Subject: Form completion: Planning Application Comments Form

refNo: 2/2021/0076

addDev: Queen Mary Terrace and Bridge Terrace

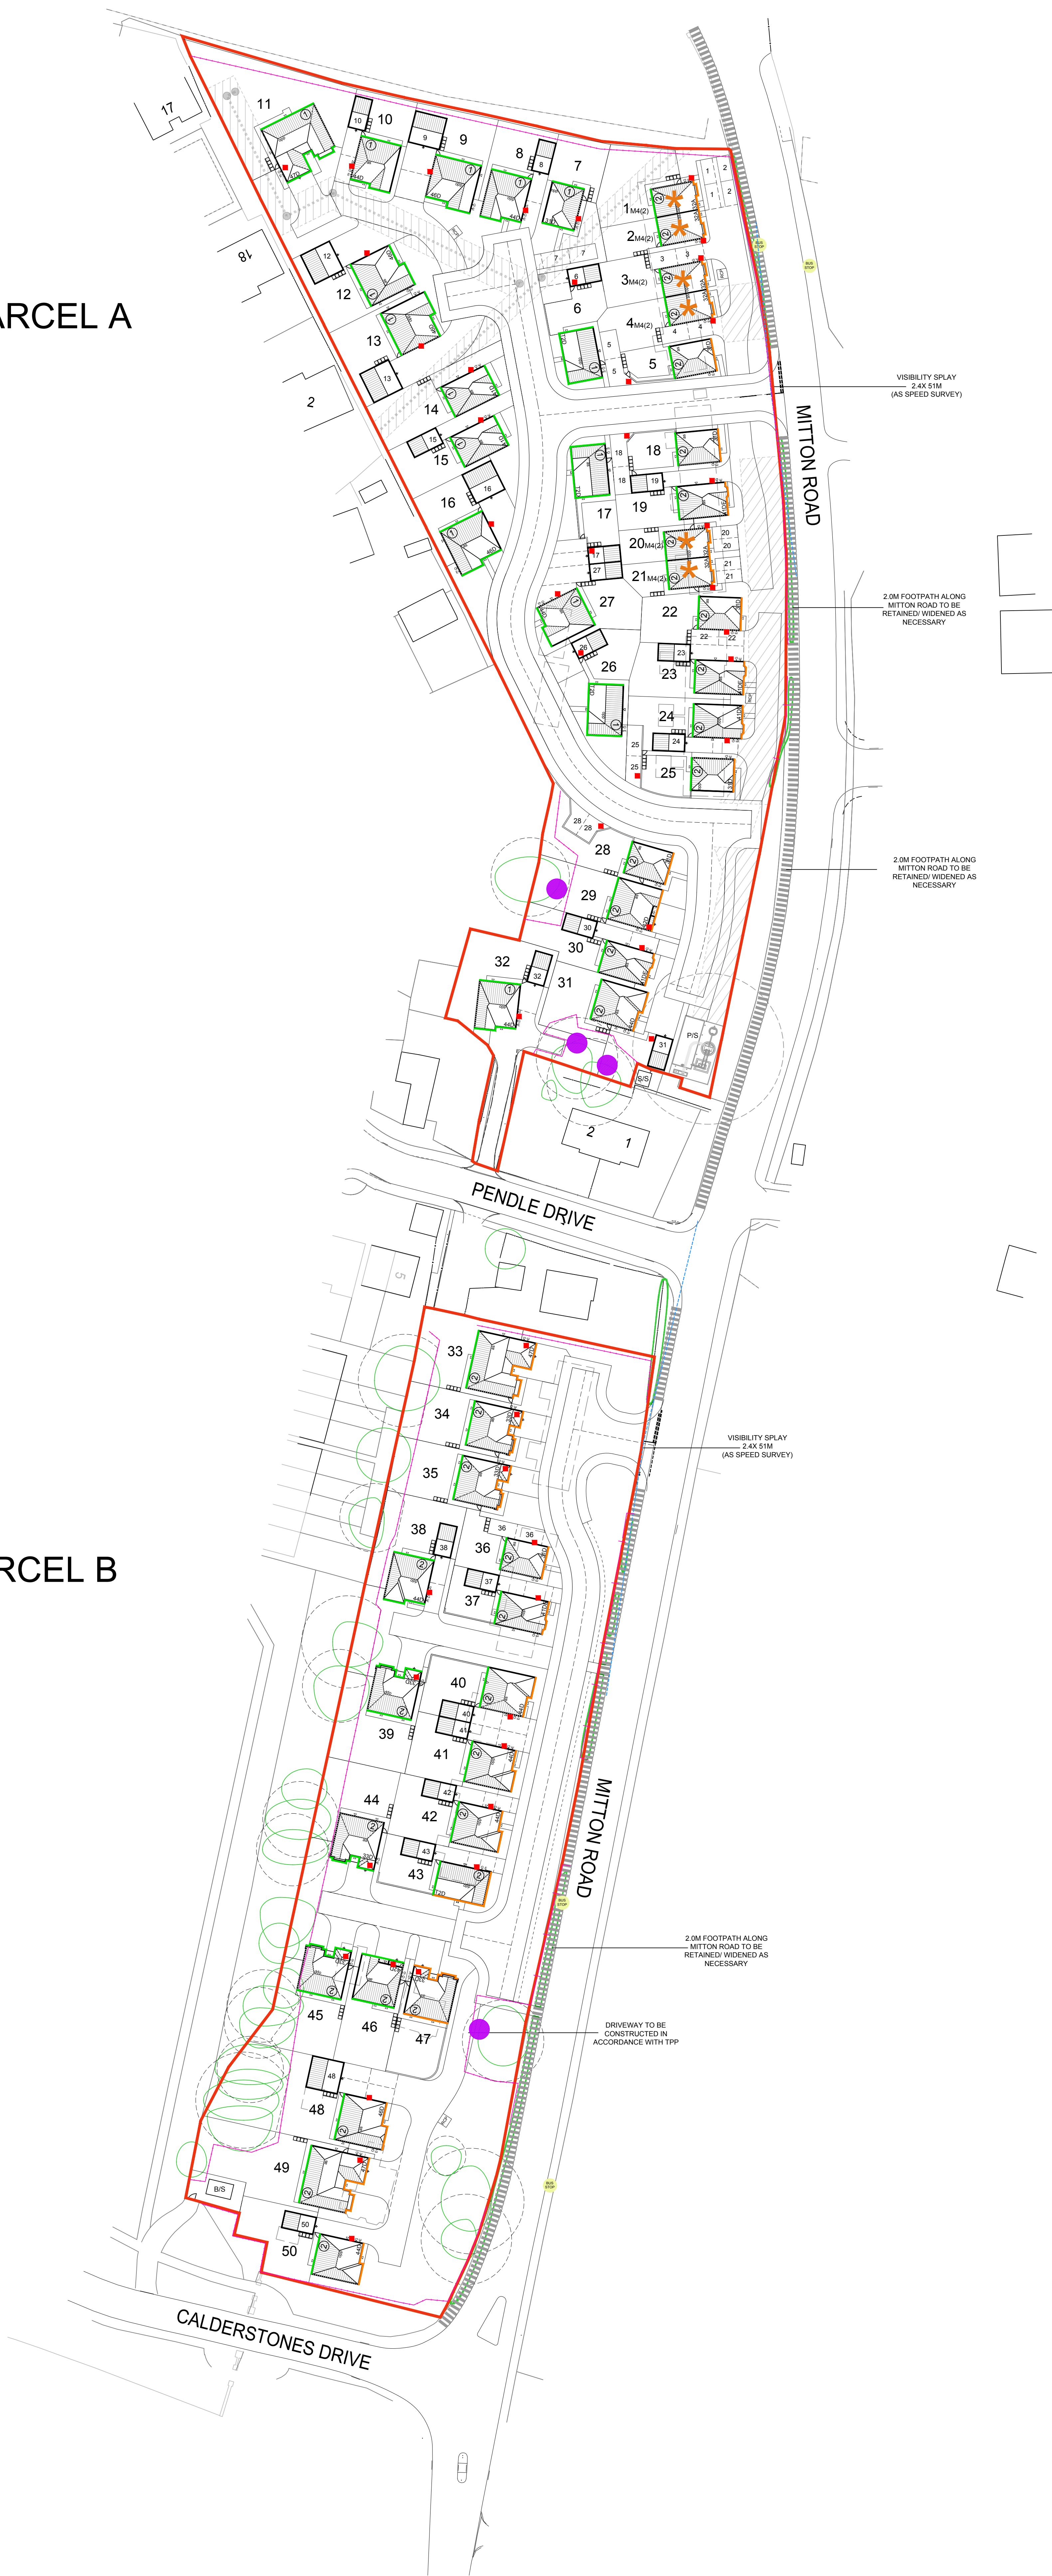
comments: Concerns with two new access roads to development from Mitton Road within close proximity to two existing access roads; Pendle Drive & Calderstones Drive. Both of which locate the current access roads to the properties. Concerns with relocation of property footprints for Queen Mary and Bridge Terrace. Proximity of coordinates needs clarification. Concerns with limited 71 parking spaces for 50 houses which are family houses 3-4 bedrooms where average household has two vehicles. Concerns with reduced parking facilities for retained NHS buildings, current facilities available however there is already access on Pendle Drive with NHS staff parking on the road, causing issues with local residents, school buses and emergency services access.
